Y/167/21/DOC

Land East of Drove Lane Yapton BN18 0EB

Approval of details reserved by condition imposed under Y/49/21/RES relating to conditions 3-in curtilage cycle stores; 4-Landscaping Measured Works Schedule, 5-alternative surfacing to those pathways shows as hoggins, 7-proposed location of required fire hydrants, 10-proposed footpath/cycle links between the ends of the cul-de-sacs on perimeter of site are at least 3m wide and feature some form of modal filler, 11-continuous footway outside plot 214 & 12-retention of existing metal estate fencing around sheep field & replacement of damaged sections and removed old sections.

Condition 12

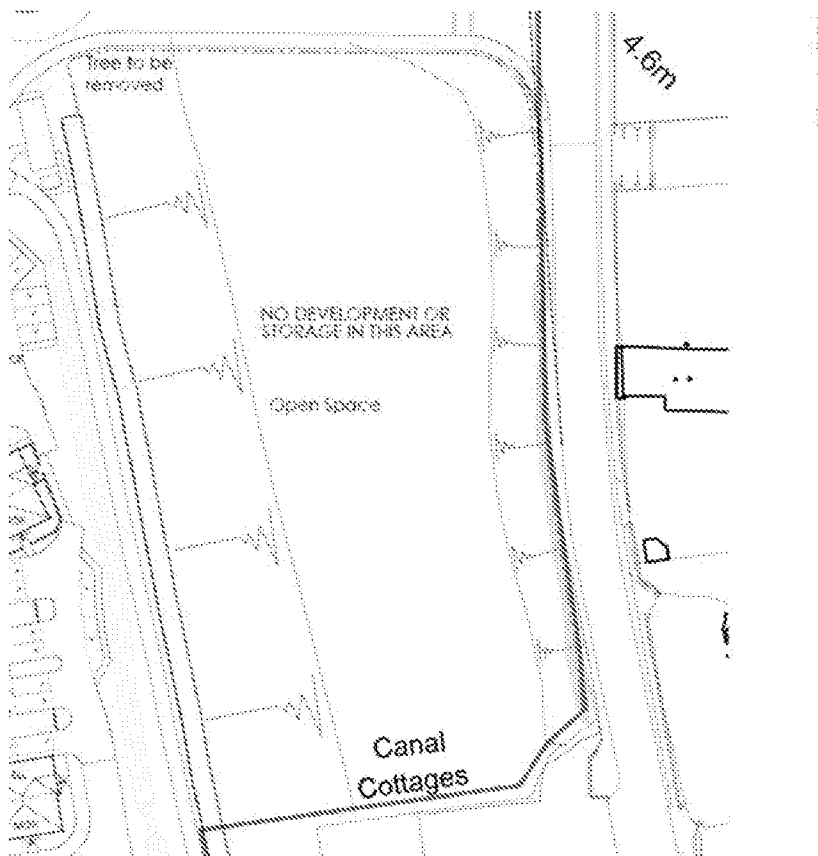
I have reviewed the plans/statements included as part of the application and am of the opinion that insufficient information has been provided. At present there is only a very basic reference to the 'Metal Estate Railing' on the boundaries plan. It is not clear how much of the existing railings will be re-used or how much of it will need to be replaced (or the reasons why). Further, there is no information regarding the proposed replacement railings, especially regarding their design, appearance, and treatment. It is also not clear if the existing railings will be painted or repaired in any way. This is disappointing, and the information should be provided in order for the LPA to fully understand the proposals.
